Application for removal or variation of a condition following grant of  
planning permission. Town and Country Planning Act 1990.  
Planning (Listed Buildings and Conservation Areas) Act 1990

Description: Residential Development of 25 dwelling houses

Location: Hill end Road, Mapplwell, Barnsley S75 6DU

Client:	ESH		
Job:	Hill End Road, Mapplewell.		
Drawing title:	Proposed Sub Station		
Drawing Number:	M3540		Revision:
(Job number)		01	
Scale:	1:50		
Date:	04/08/2016		
Drawn by/ checked by:	CS

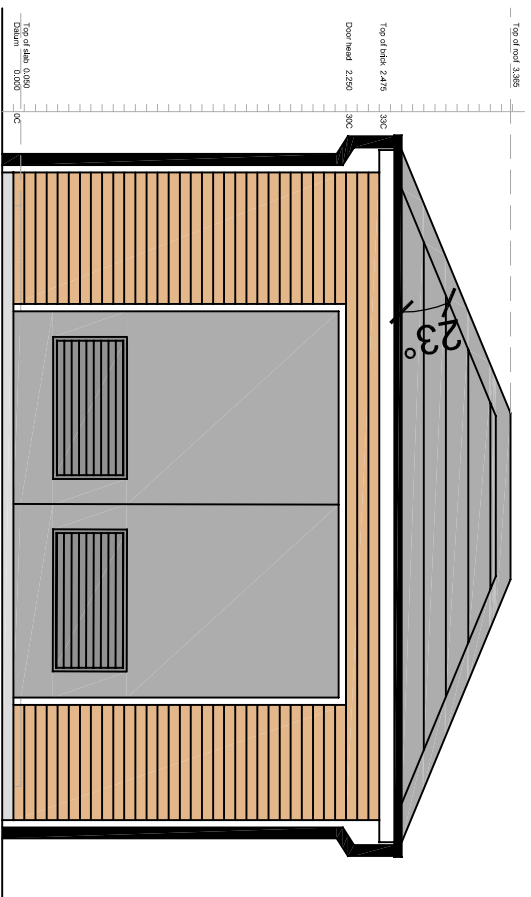
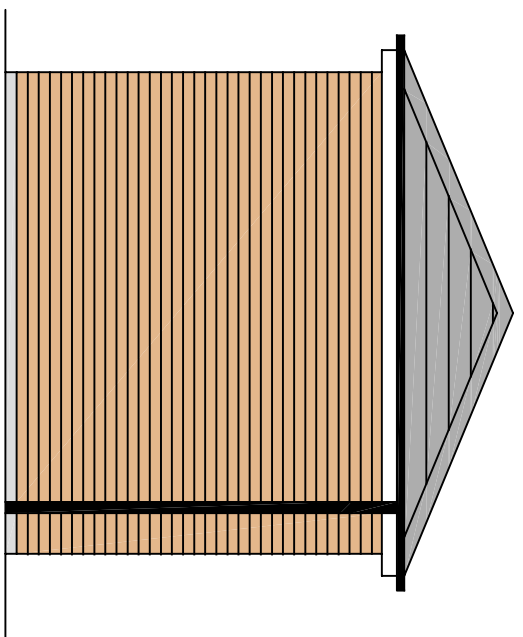
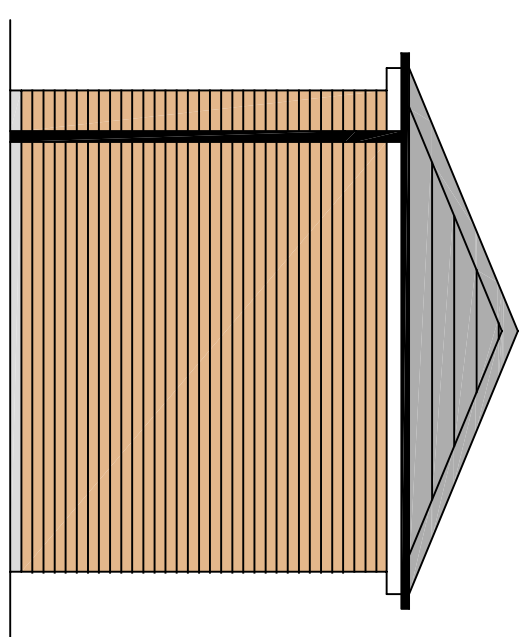
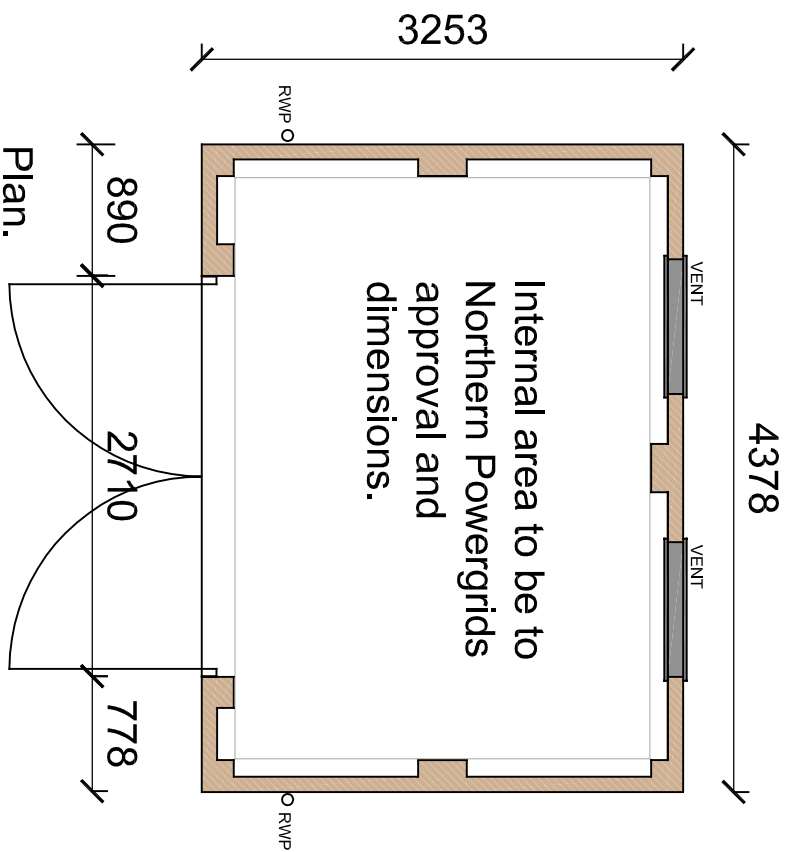
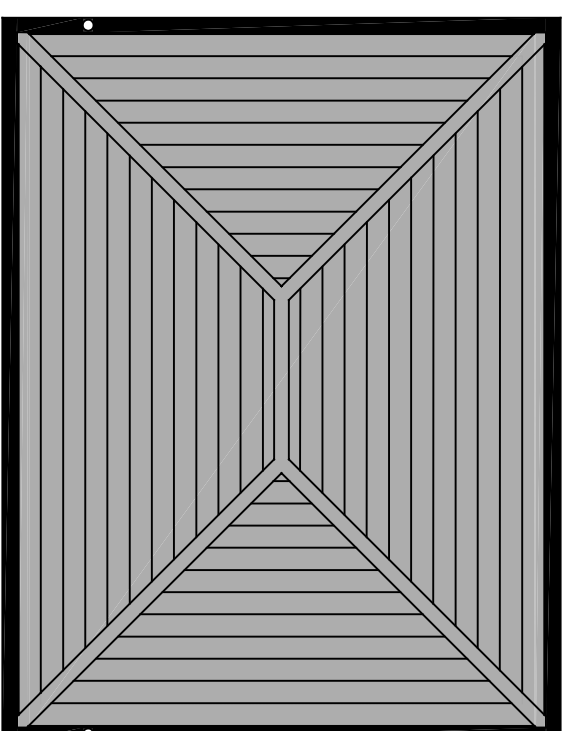
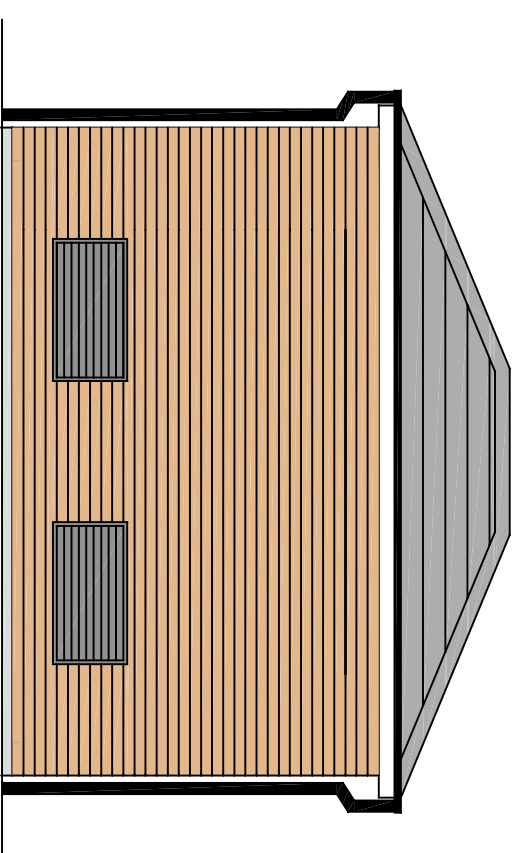
13. Drive to plot 24 amended
14. Revised garden area to plot 25.
15. Sub station added to rear of plot 6.
16. Perimeter trees removed to rear of plots 7,8 and 9.

| Drawing title: | SITE LAYOUT |

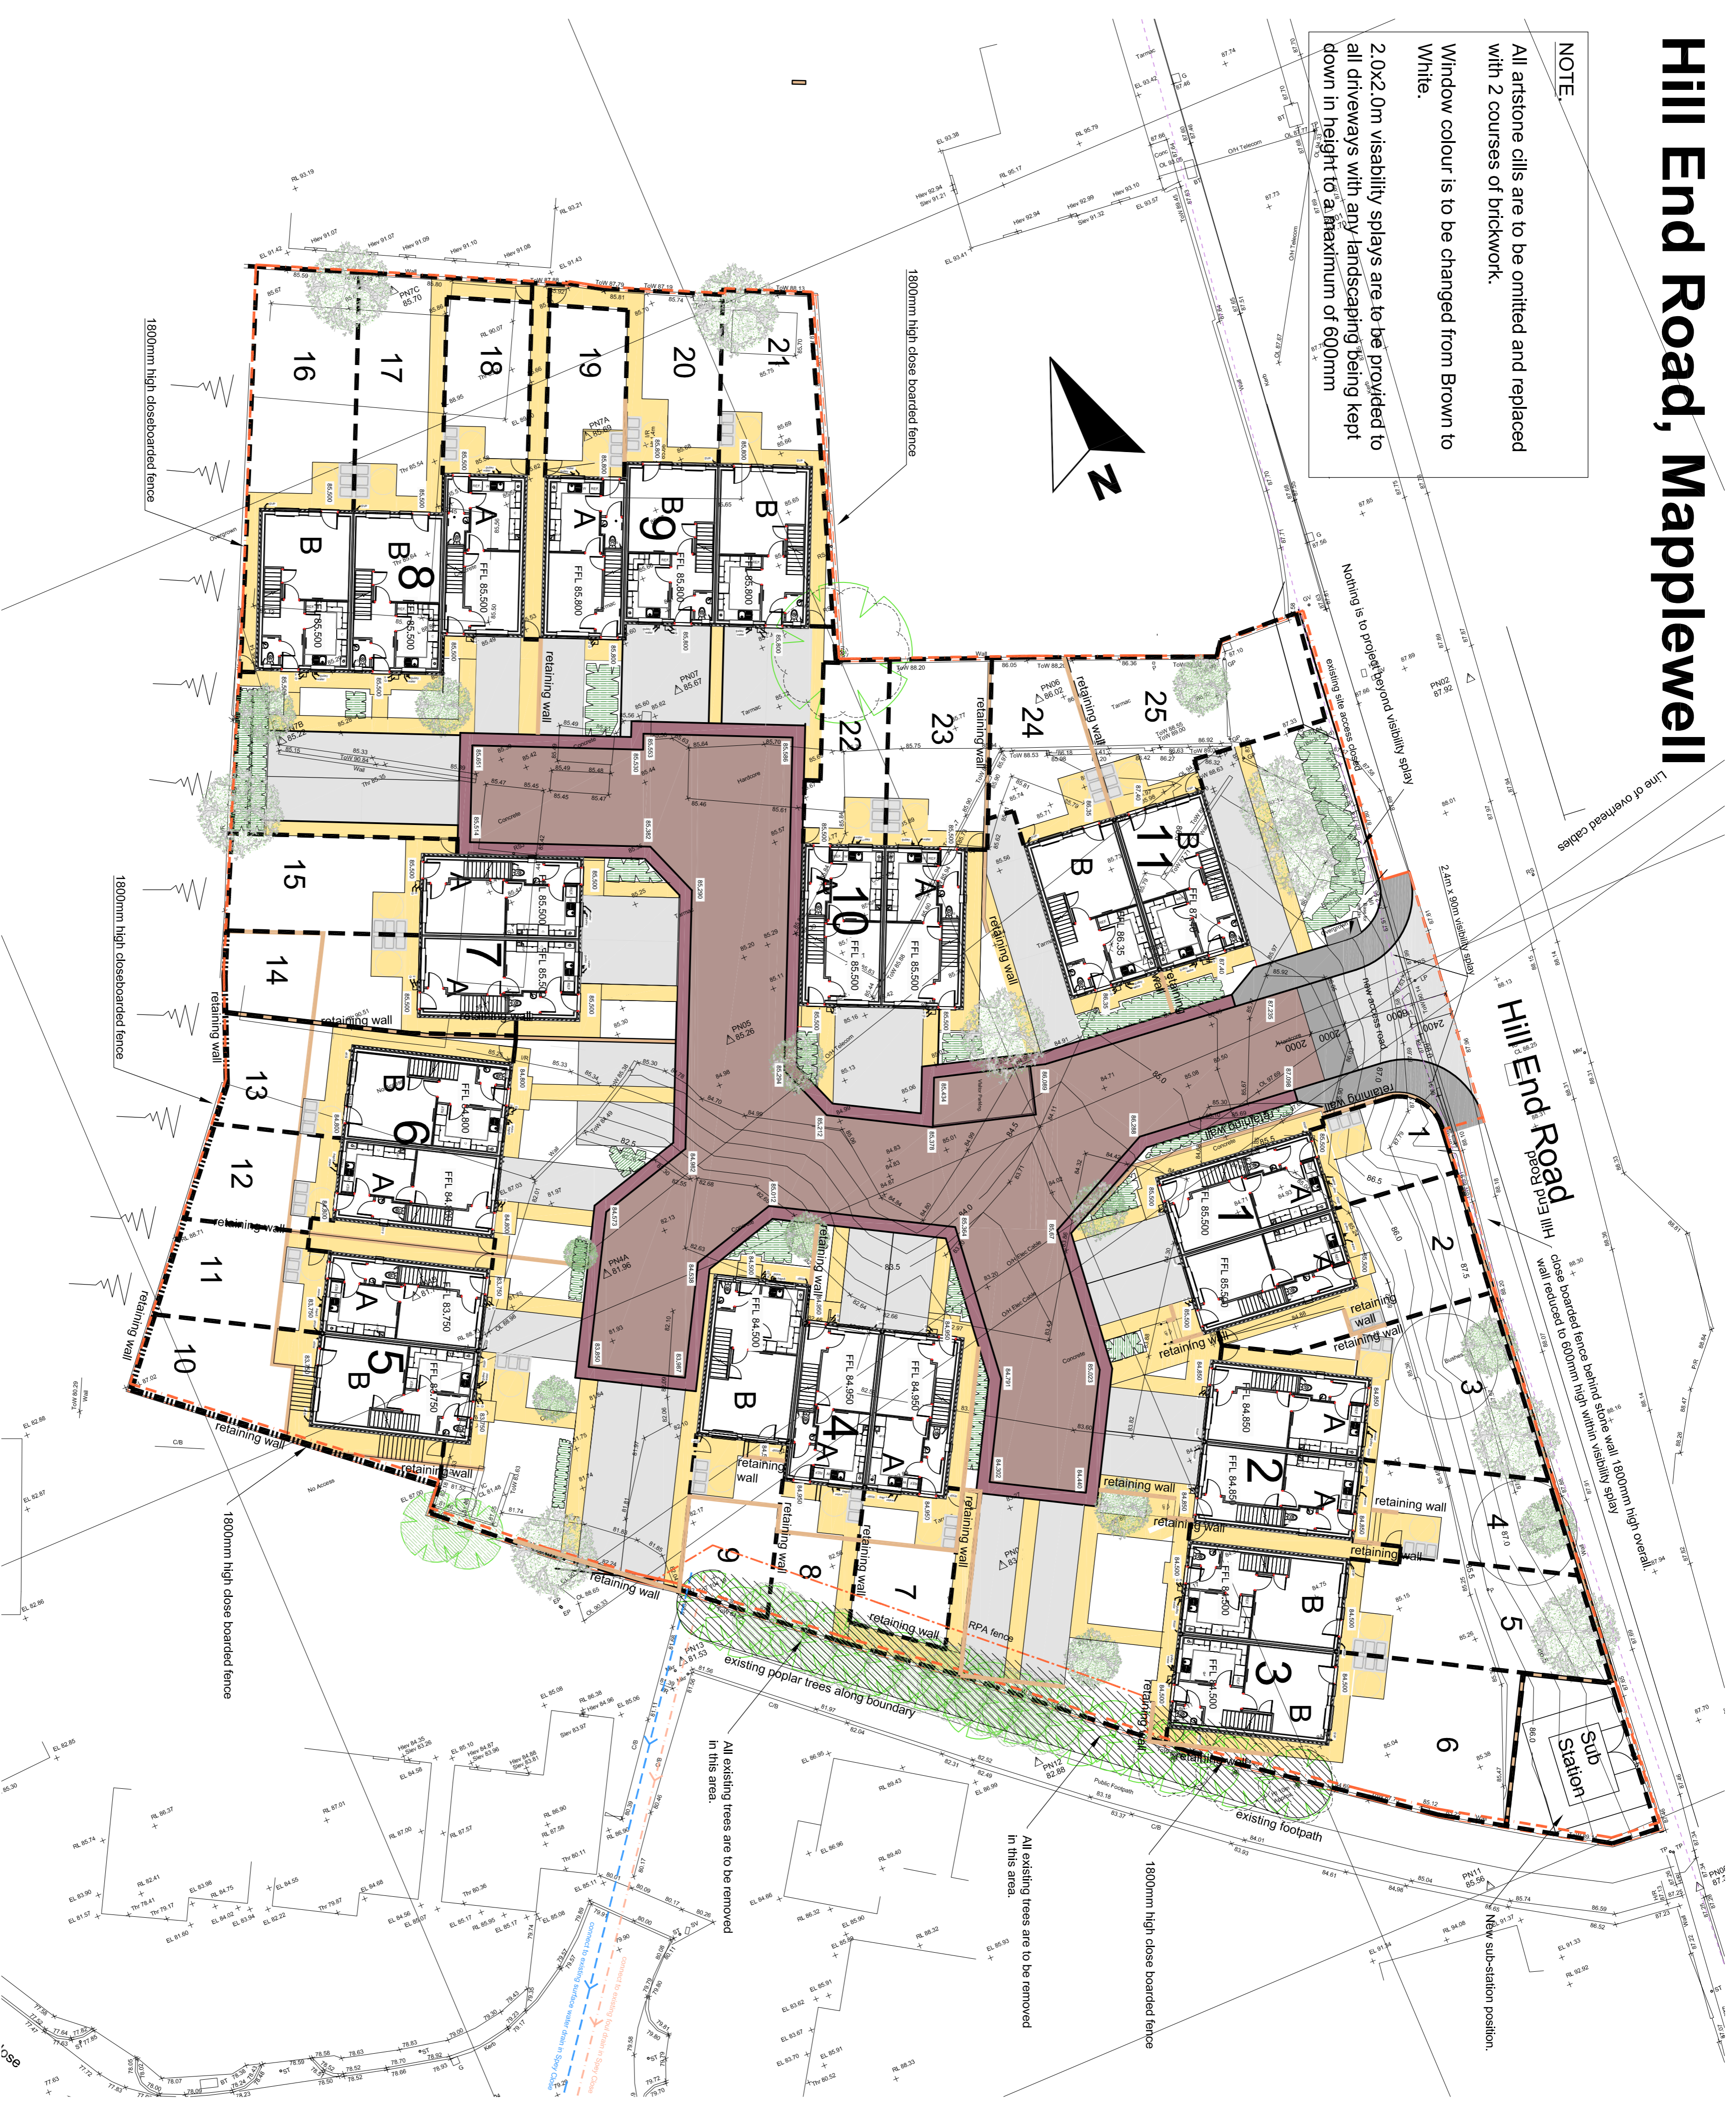
Further to receipt of planning approval the scheme has been detailed further predominantly in respect of reaching agreement with Barnsley MBC highways section. This has necessitated the alteration of levels and alterations to the highways layout. In addition the requirement for an electrical substation on the site has been identified by Northern Powergrid.

1. All steps and ramps removed to rear gardens
2. All sheds removed from gardens
3. All rotary dryers removed from gardens
4. Rear boundary fence heights reduced from 3.0m to 1.8m.

5. All water butts removed.
6. Miscellaneous retaining walls removed.
7. Extend of hard surfacing on the site reduced.
8. Alterations(minor) to positioning of plots 1,2 / 3,4 / 7,8,9 / 10, 11, 12, 13 / 14, 15 / 16, 17, 18 / 19, 20, 21, 22, 23 in order to accommodate highway departments requirements of driveway lengths and road widths etc

9. Site entrance alteration to accommodate highway departments requirements.
10. Margin on highway increased to 700m to comply with highway departments requirements.

11. Grit bin space added to comply with highway departments requirements.
12. Visitor parking spaces amended to comply with highway departments requirements.

17. Car parking to plots 12 and 13 amended.

18. Car parking to plots 15 and 16 amended.
19. Plot boundary to units 12 /13 amended.
20. Road and margin amended to block paving to comply with highway departments requirements.

The development hereby approved shall be carried out strictly in accordance with the plans (Nos (90) 01G, (PL) 01, (PL) 02, (PL)04, (PL) 06 and (PL) 08 and specifications as approved unless required by any other conditions in this permission.
